From: Maria Tomalova
Sent: 21 May 2019 14:37
To: Planning.Responses
Subject: FW: P/2/19/PL, 7 Webb Close
Attachments: 17017_601 Roof Windows.pdf

PROPOSED ELEVATIONS

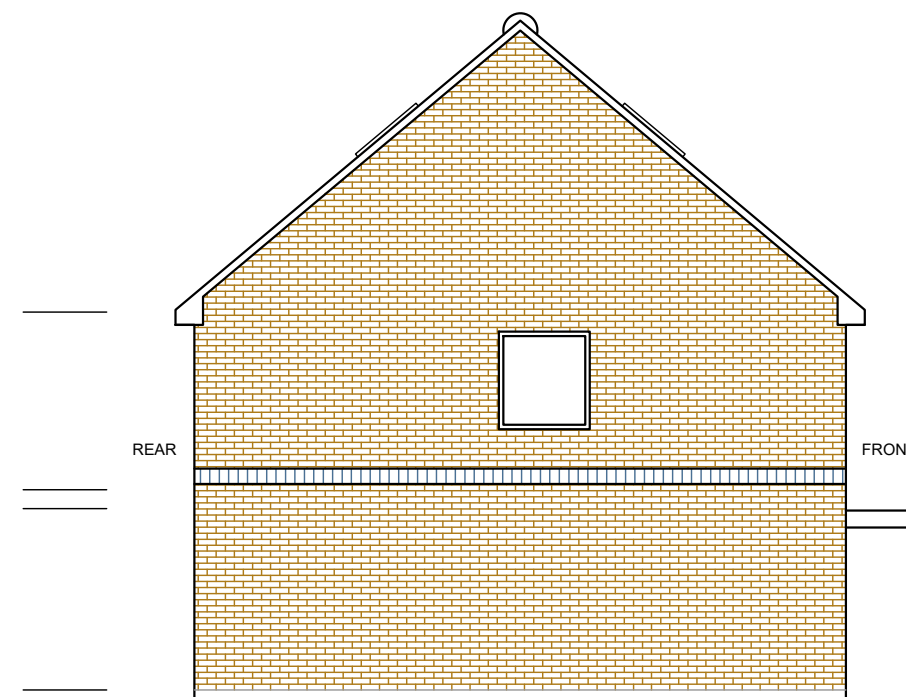
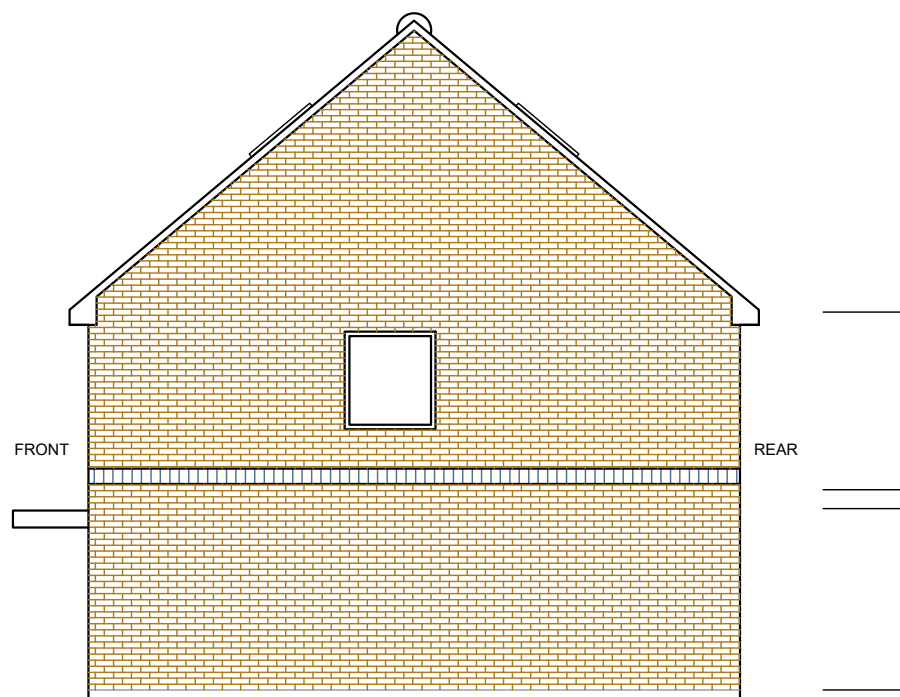
I would like to ask you for the provision of a section showing the position of the proposed velux windows from the finished floor level of the proposed bedroom.

17017-601⁰

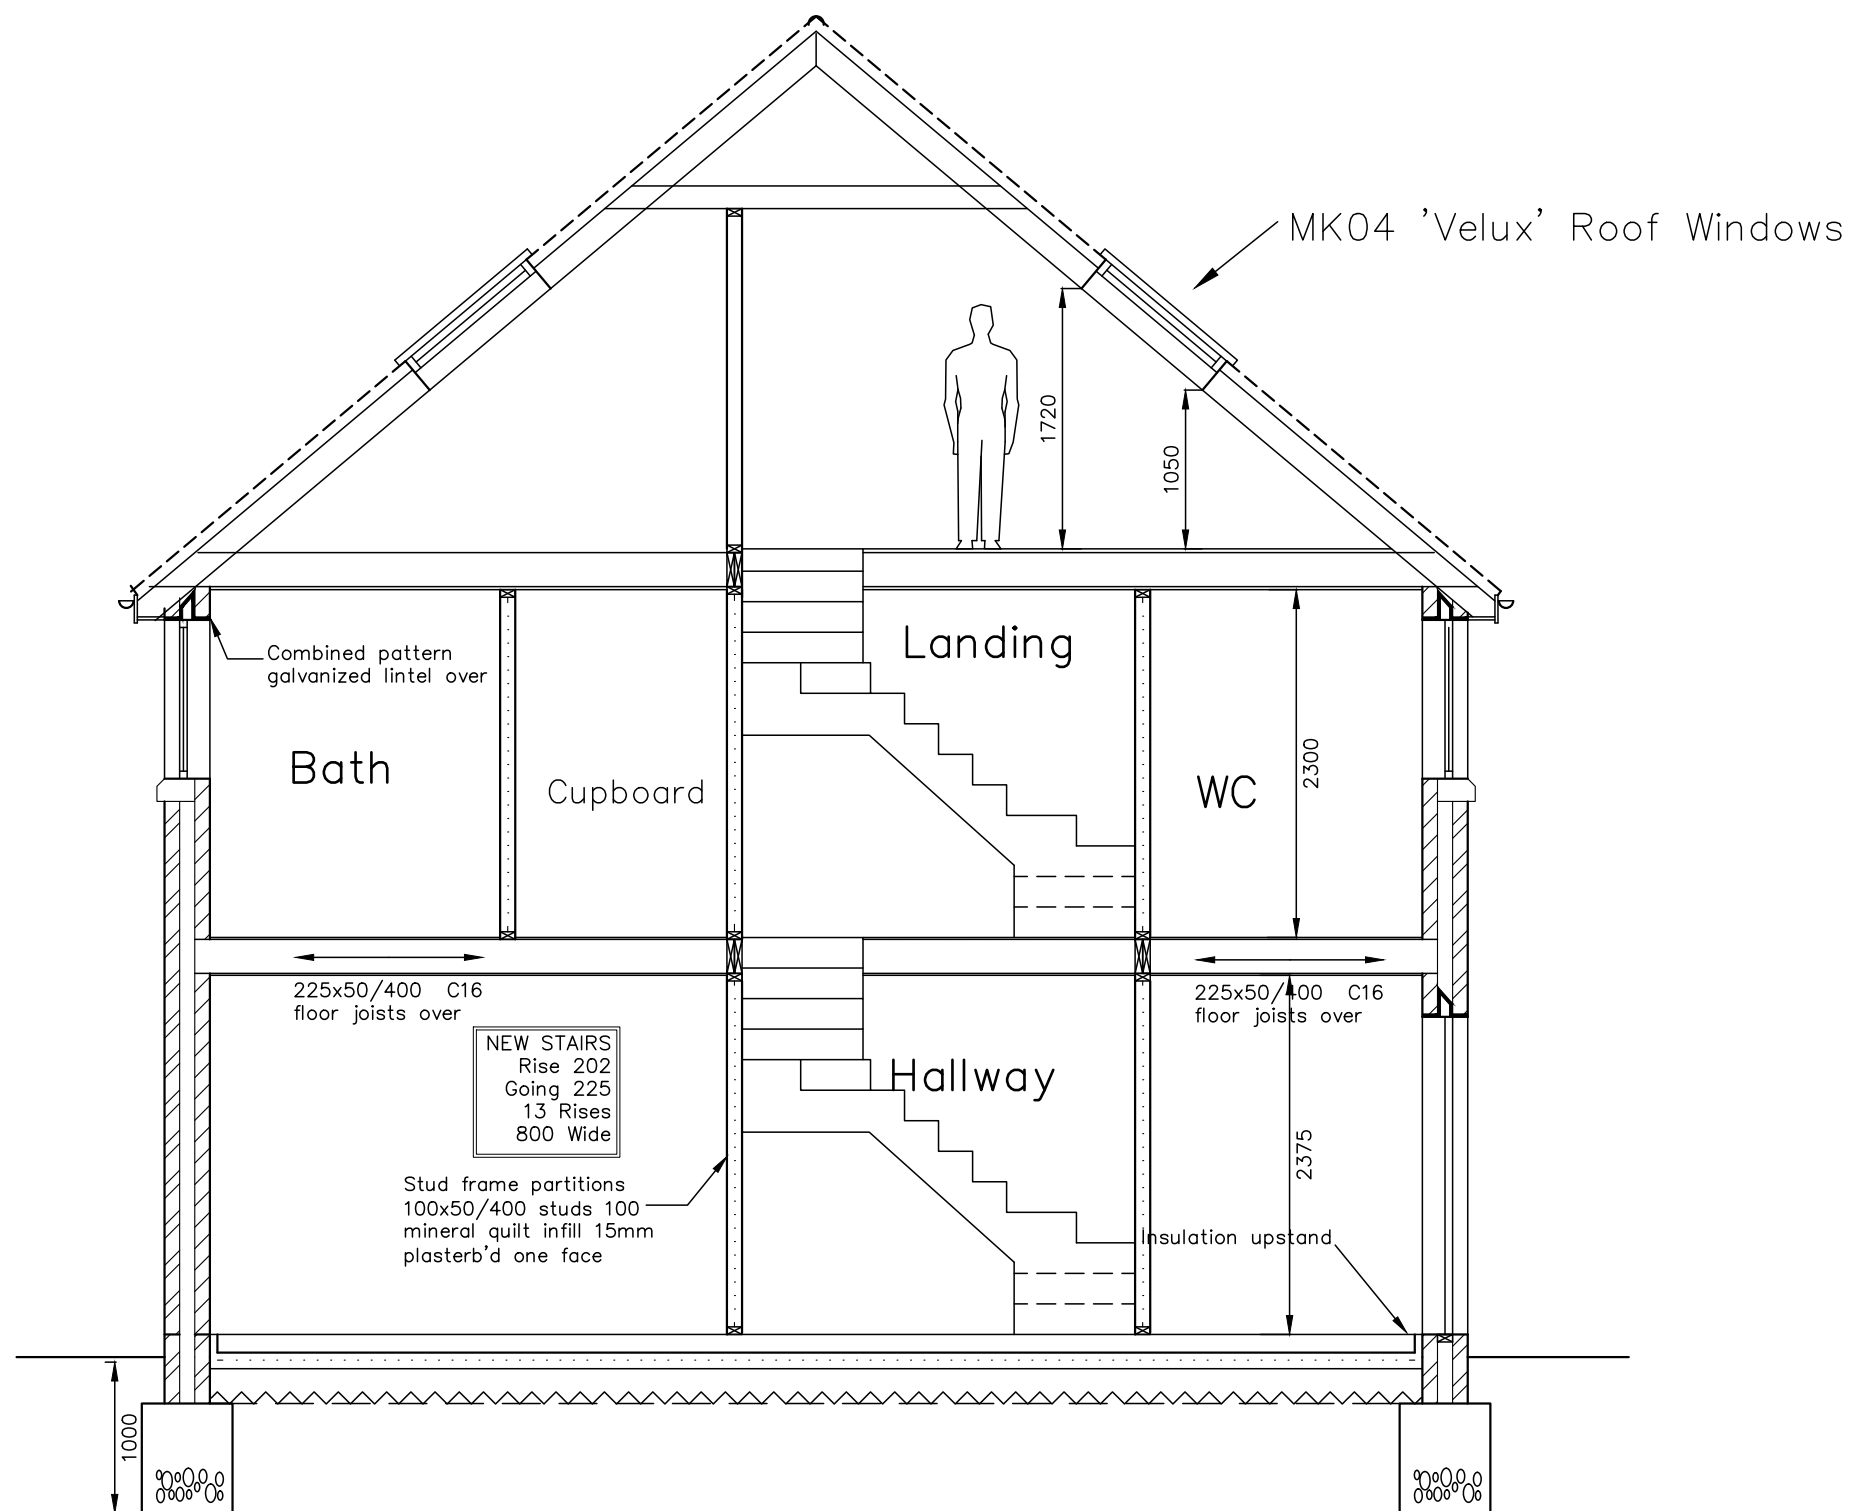
In case you can't provide the section, your confirmation of the high level of the proposed velux will be sufficient.

This requirement is due to the possibilities of the further overlooking and the objections received.

Further to your email, please find attached drawing 17017_601, as requested.
